KITTITAS COUNTY

MEMORANDUM

TO: All Staff
FROM: Public Works Planning Review Team
DATE: November 30, 2020
SUBJECT: BL-20-00025 Cle Elum Pines West

ATTACHMENT A.
- NEW Configuration

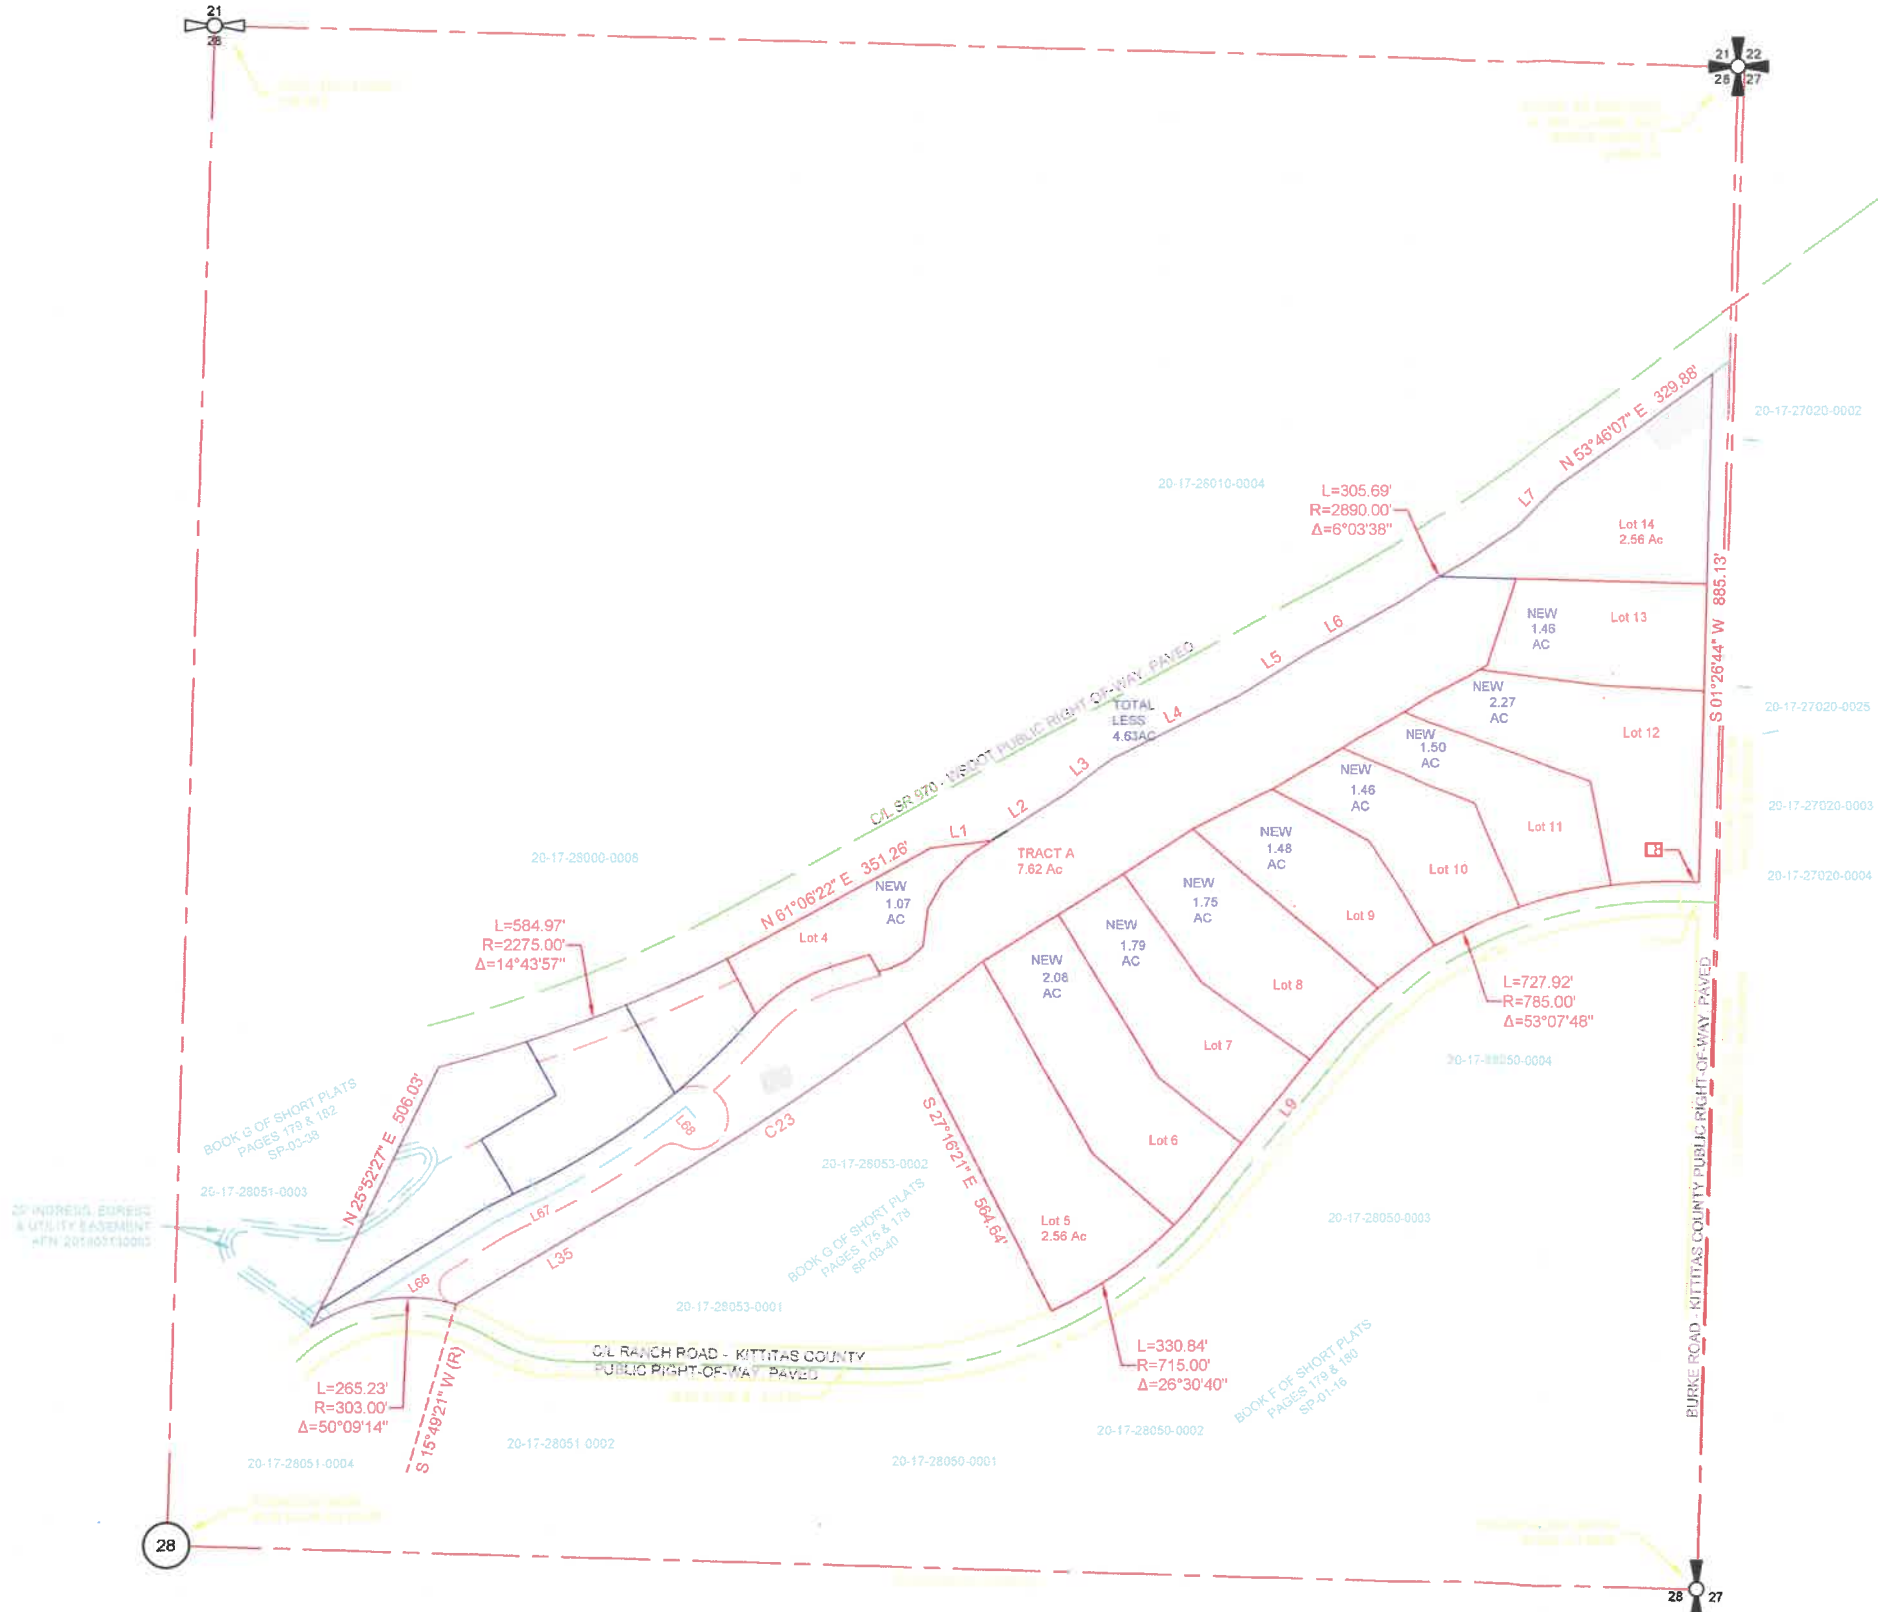
1. A survey map for review
2. A revised legal description that describes the final configuration of the subject property shall be required.

- a. Any access easements shall be shown on the face of the BLA
- b. Maintenance of driveway approaches shall be the responsibility of the owner whose property they serve. The County will not maintain accesses.
- c. Any further subdivision or lots to be served by proposed access may result in further access requirements. See Kittitas County Road Standards.
- d. Evidence of existing access and/or evidence of access to be created should be confirmed prior to sale of property.
- e. Access is not guaranteed to any existing or created parcel on this application.

As the application does not contain a survey map, any comments will be reserved until final.

Floodplain

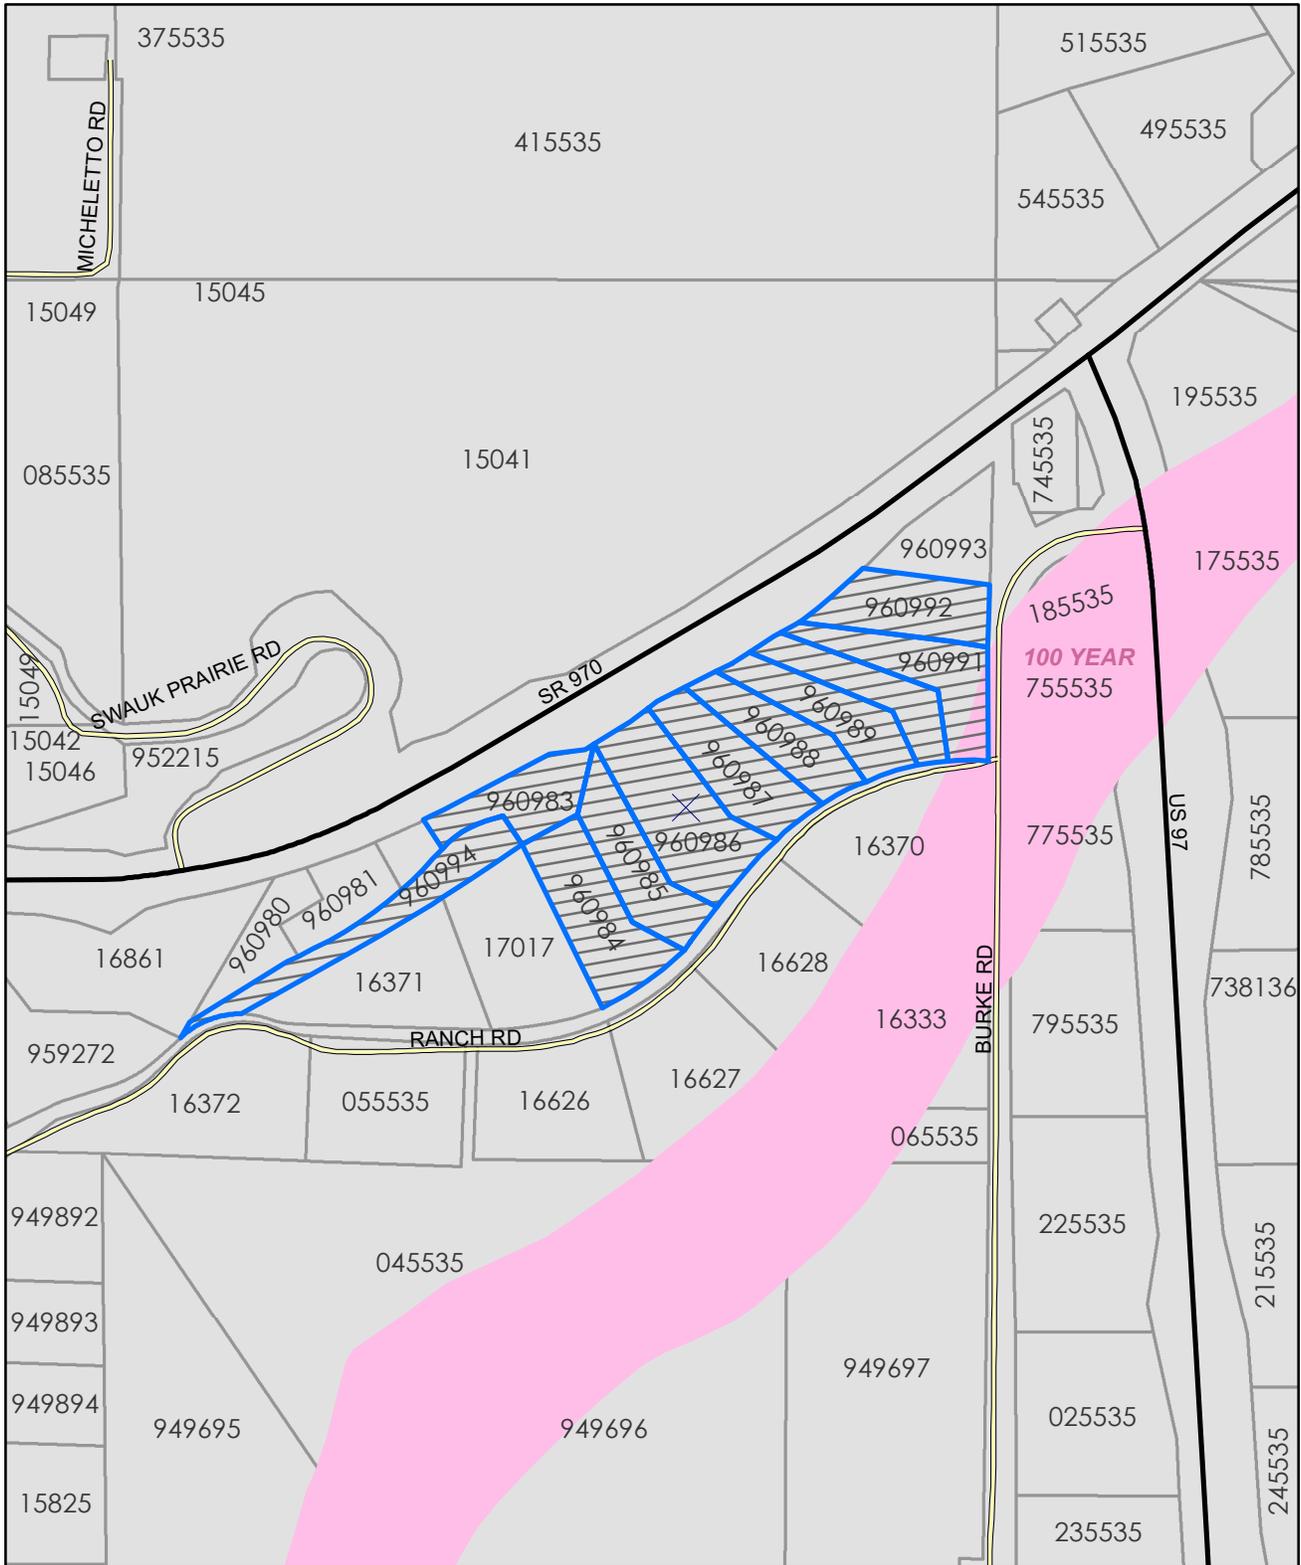
A portion of parcel #960991 is within the 100-year floodplain. If possible, any future development should remain outside of the floodplain in order to reduce risk and avoid mandatory flood insurance purchase requirements. All activities within the floodplain must be permitted through the floodplain development permit process and follow the regulations within KCC 14.08.
